Recommendation Report for Works to Tree(s) on trees subject to a Tree Preservation Order (TPO)

REF NO: AW/354/20/T

LOCATION: 4 The Spinney
Aldwick
PO21 3RL

PROPOSAL: To reduce 3 No. Maple Trees (T2) lateral branches to 6.5m, which are overhanging garage by 1.5 metres.
To reduce 1 No. Oak Tree (T1) lateral branches to 7m spread.

1) Oak tree

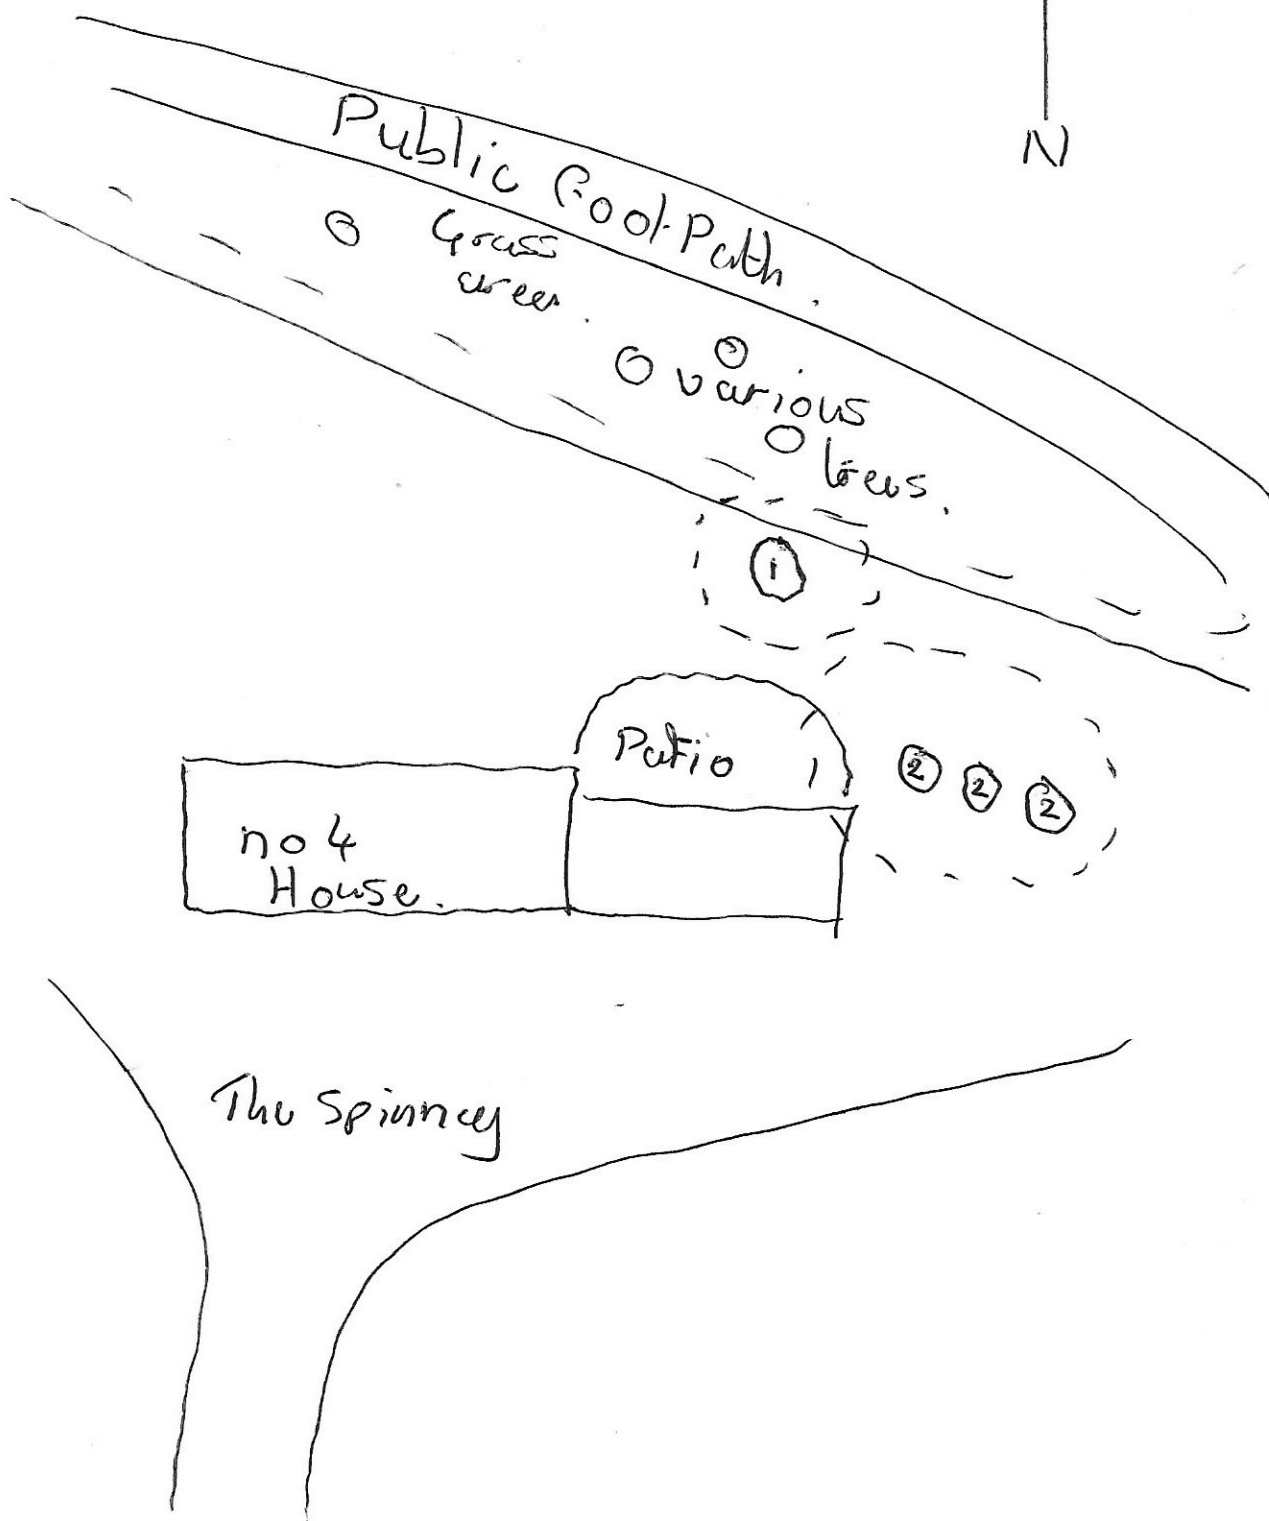
T1 has slight asymmetric form and with evidence of past pruning to accommodate buildings. Negligible crown extension over patio and with lateral spread towards house/garage approximately 7metres; pruning to the extent described will be minimal and should not have any detrimental effect on the tree.

I recommend CONSENT for this application, subject to the following condition:

Part a) Where whole branches are to be removed and final cuts made close to the trunk or branch union they are to be made as shown in Figure 2 of BS3998:2010

Part b) Where branches are to be shortened back the final cuts are to be made at the correct angle shown in BS3998:2010 and adjacent to a live bud or lateral.

T2 as 3 of 4 maple in a tight group. Shared crown profile with evidence of past pruning to accommodate buildings. Minor pruning of one aspect to achieve long-term clearance so ought not to have any detrimental effect on the trees.
